**For the attention of the Examining Authority for the Manston Airport regarding Supplementary Relevant Representation**

On 8 October 2018 the RSPB submitted a relevant representation on the application for development consent by RiverOak Strategic Partners Ltd for Manston Airport (registration identification number 20014646).

Since sending our representation we have noticed an error in the Environment Statement (dated July 2018, reference TR020002/APP/5.2-1) that accompanied the application.

Figure 7.1
Statutory designated nature conservation sites

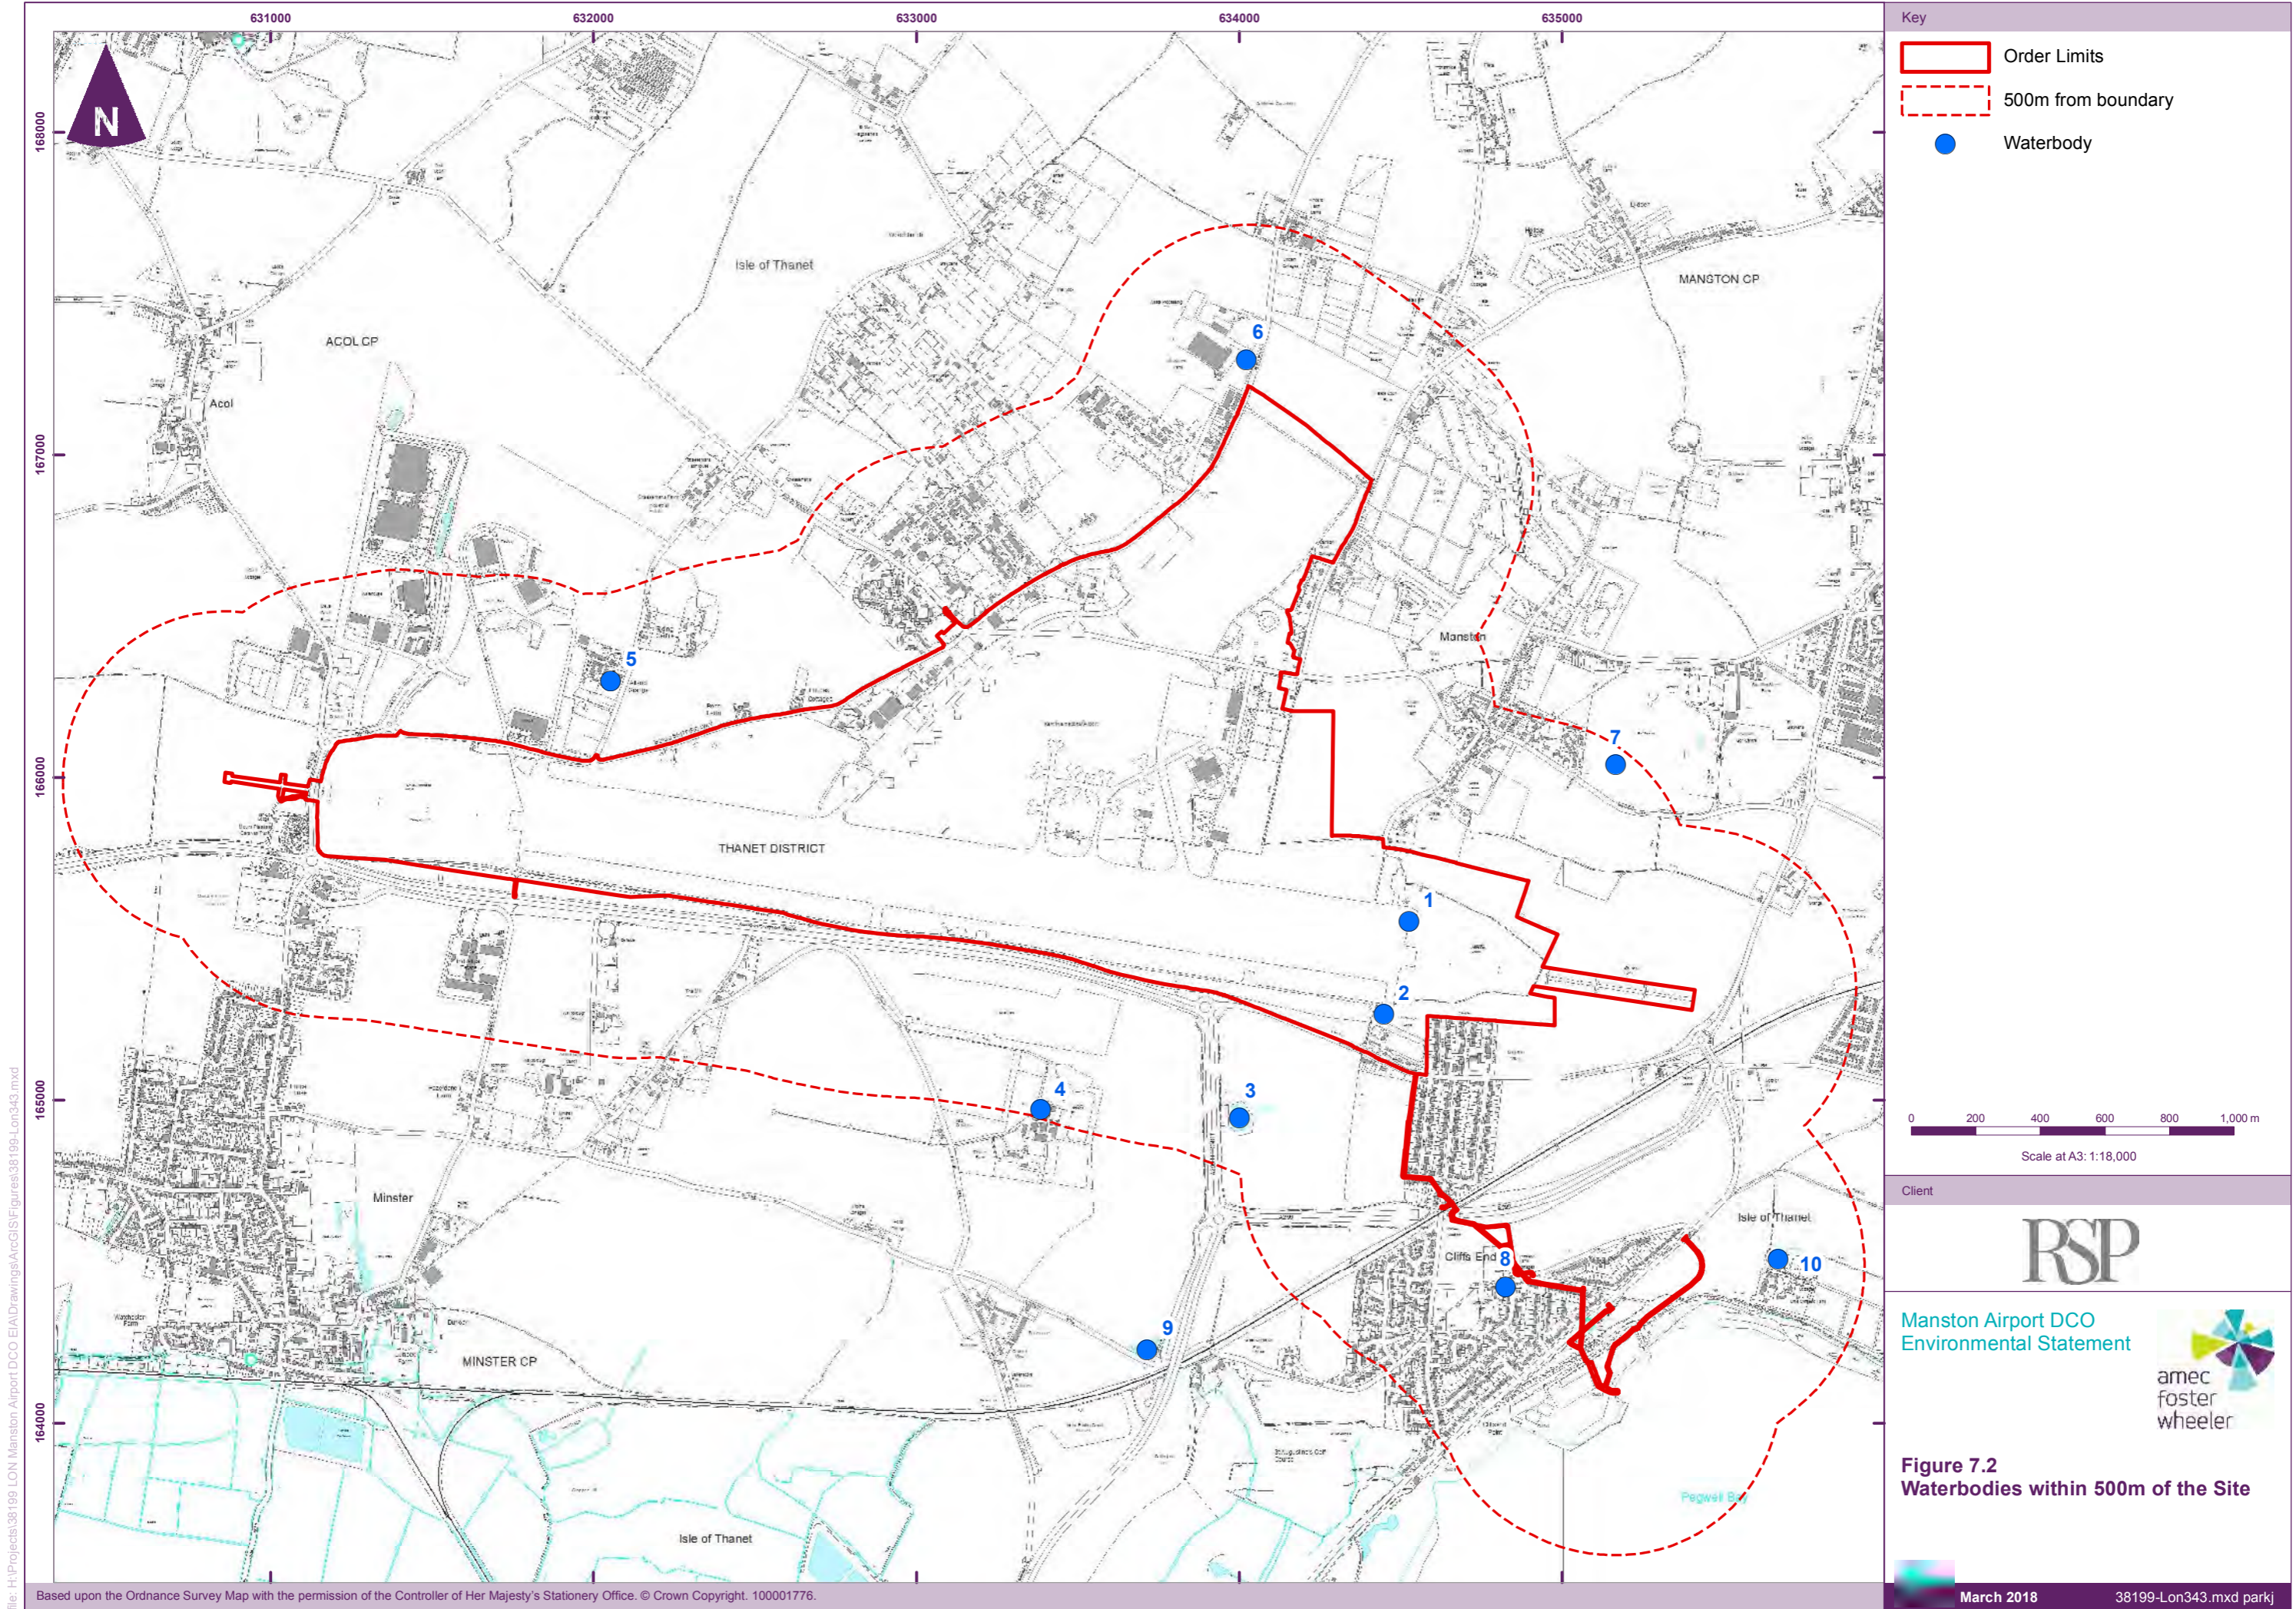
- “as part of the third Joint Nature Conservation Committee (JNCC) SPA review<sup>1</sup>, golden plover was removed as a designated species from the (Thanet Coast & Sandwich Bay) SPA (likely due to declining numbers), although this change is currently unratified” (page 7-35, paragraph 7.8.7)
- “Following the third JNCC review (Stroud et al. 2016) of the SPA designated species, it was suggested little tern be removed, due to recent absence from the (Thanet Coast & Sandwich Bay) SPA, although this change is as yet unratified” (page 7-38, paragraph 7.8.28).

These two statements are incorrect.

Phase 1 assessed whether the UK's network of Special Protection Areas (SPAs) is sufficient for the bird species listed in Annex 1 of the Birds Directive. It did not assess whether a species should or should not be removed as a designated species for any SPA.

Therefore, the Environment Statement is incorrect when it states that the Review has removed or suggested the removal of golden plover or little tern from the designation of the Thanet Coast & Sandwich Bay SPA.
